MEMORANDUM

TO: Kylie Bagley, Planner II, El Paso County Planning Department
FROM: Peter Patten, Patten Associates, Inc.
RE: Response to EPC and Agency Review Comments on Silverado Ranch Plat Amendment and Associated Waivers
DATE: May 31, 2023

This memo serves as our detailed responses to staff comments posted on EDARP for Silverado Ranch Plat Amendment – EPC File # VR237.

SILVERADO RANCH
JULY 5, 2023
PROJECT 16093
SHEET 1 OF 3

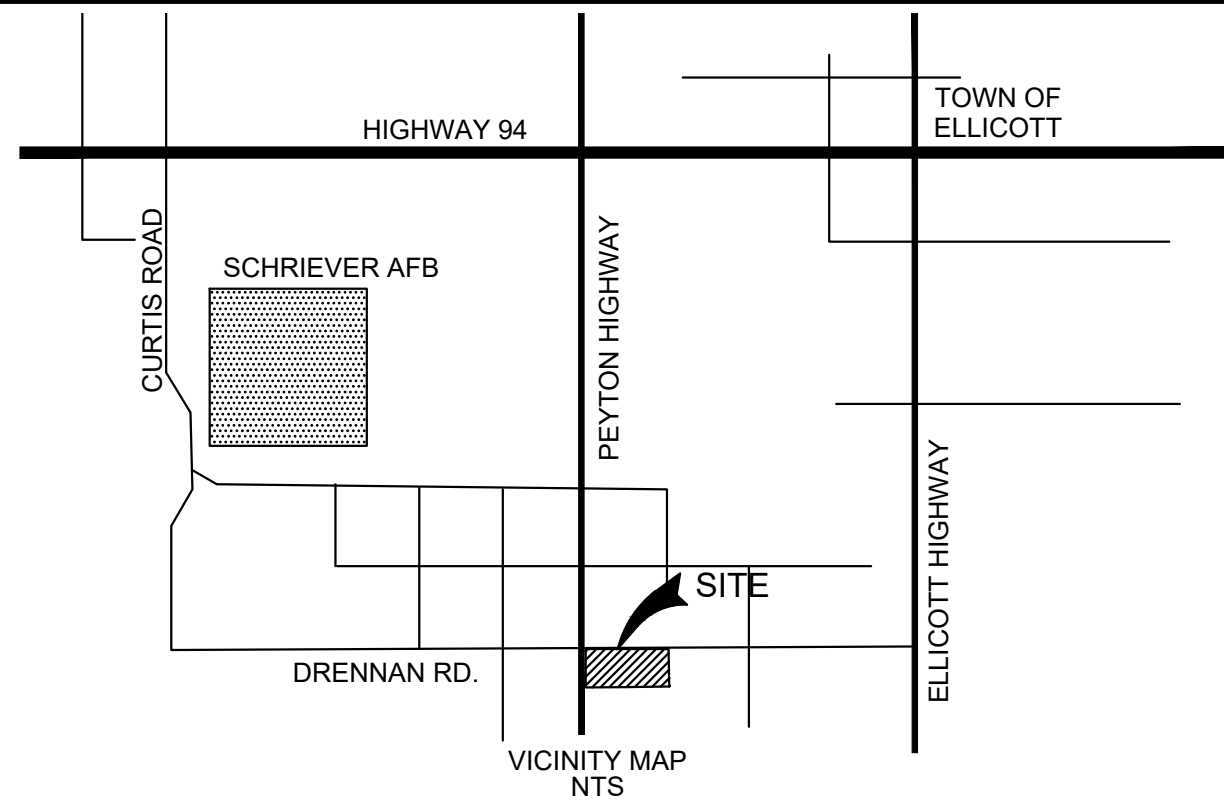
Sheet 1

- Update Note #28 to include the following: “The subdivider(s) agree on behalf of him/herself and any developer of builder successors and assignees that subdivider and/or said successors and assigns shall be required to pay traffic impact fees in accordance with the El Paso County Road Impact Fee Program (Resolution No. 19-471), or any amendments thereto, at or prior to the time of building permit submittals. The fee obligation, if not paid at final plat recording, shall be documents on all sales documents and in plat notes to ensure that a title search would fine the fee obligation before sale of the property.”**
Plat note will be updated. This is now Plat Note #27.

- Signatures under BOARD OF COUNTY COMMISSIONERS CERTIFICATE: Change “President” to “Chair” and Delete Signature Lines for Director, County Planning and Community Development and County Assessor**
These changes will be made.

4. Update Note #30: “The private roads as shown on this plat will not be maintained by El Paso County until and unless the streets are constructed in conformance with El Paso County standards in effect at the date of the request for dedication and maintenance.”
Plat note will be updated. This is now Plat Note #29.
5. Revise Clerk and Recorder Signature Block as noted on Final Plat (Kylie Bagley comment)
The recording block for the County Clerk and Recorder is standard and has been that format for years, it was not changed except to reflect the name of the current Clerk.

SILVERADO RANCH FILING NO. 1A

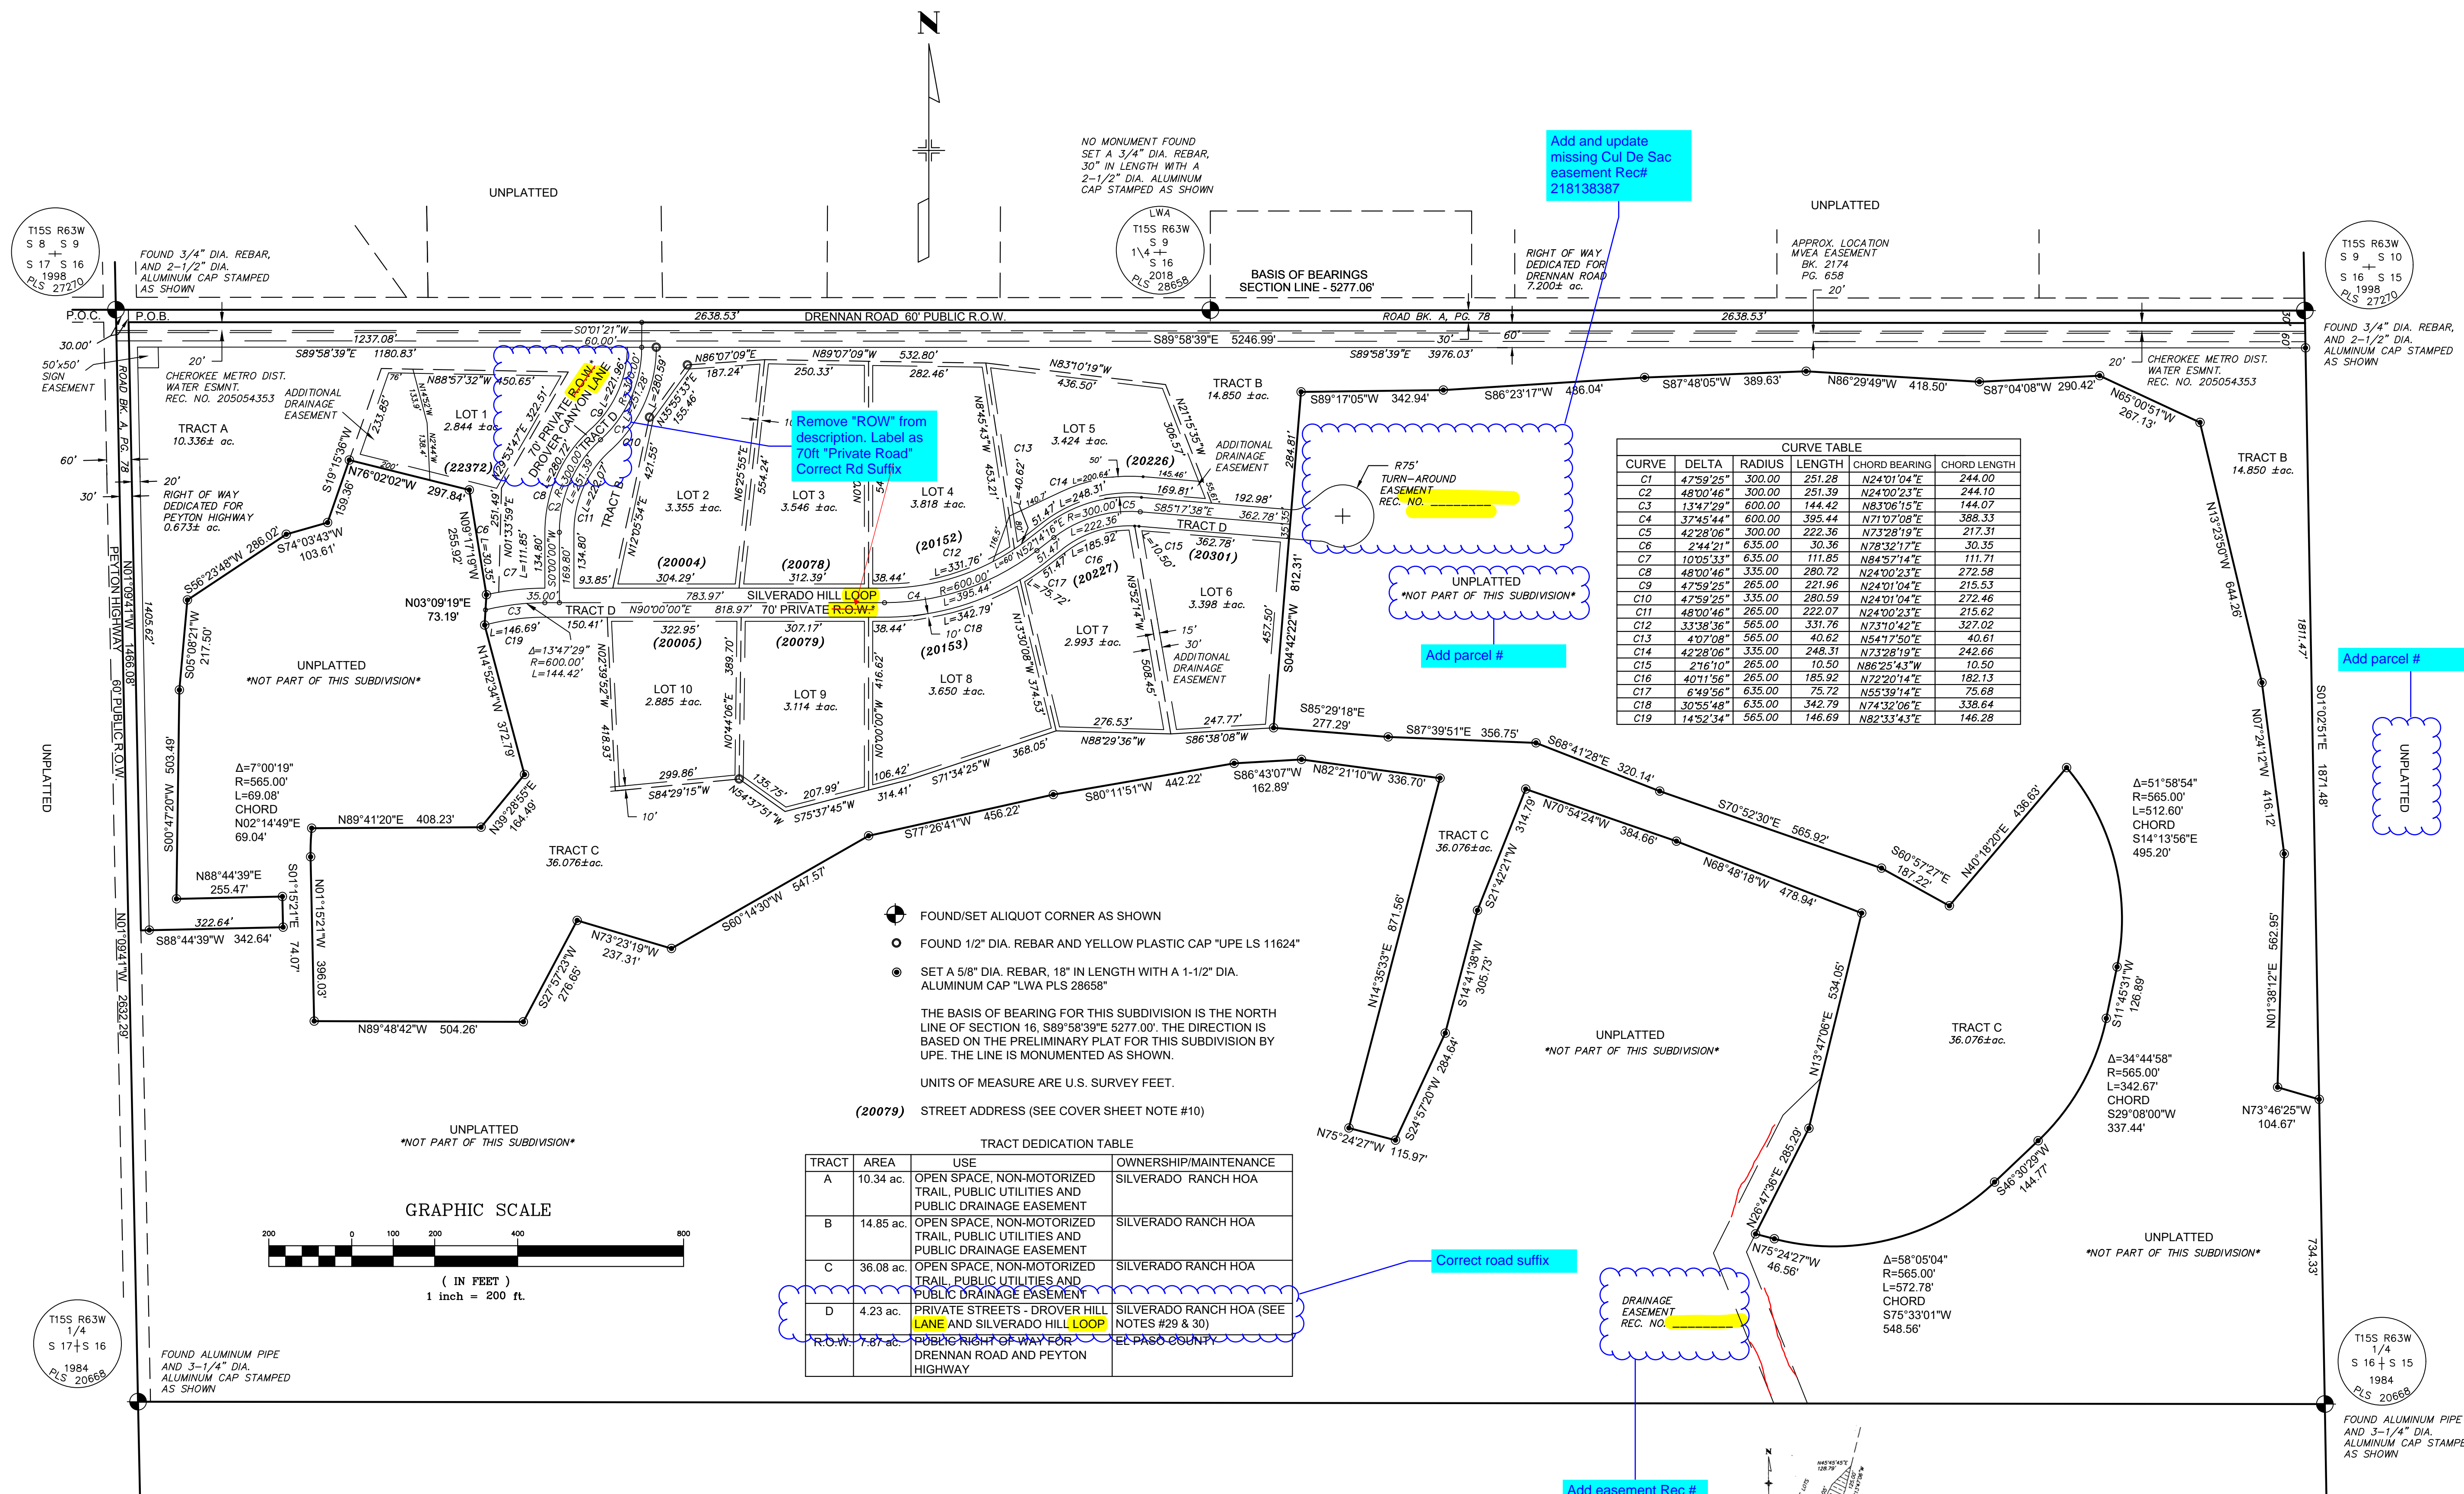
Sheet 2

1. Remove “ROW” from description (two places). Label as 70 ft. “Private Road” and Correct Rd Suffix
“ROW” will be deleted in two places and labeled as “Private Road.” Street names will be changed to Drover Hill View and Silverado Hill View.

2. Add and update missing Cul De Sac easement Rec#218138387
Missing easement will be added.
Add parcel # (where current plat has label of: “UNPLATTED *NOT PART OF THIS SUBDIVISION*) + Add parcel # (on “UNPLATTED” parcel east of property boundary).
Assessor’s Parcel numbers are not added to the plat. That is not a final plat item and should not be on the plat. Parcel numbers change over time and are merely a classification number for the assessor.

3. Tract Dedication Table: “Correct road suffix” for Tract D which says “PRIVATE STREETS – DROVER HILL LANE AND SILVERADO HILL LOOP”
Street names will be changed to Drover Hill View and Silverado Hill View.

4. Add easement Rec #218138386 Add azimuth and lengths (for Drainage Easement west and south of Tract C)
Missing easement, azimuth and lengths will be added.
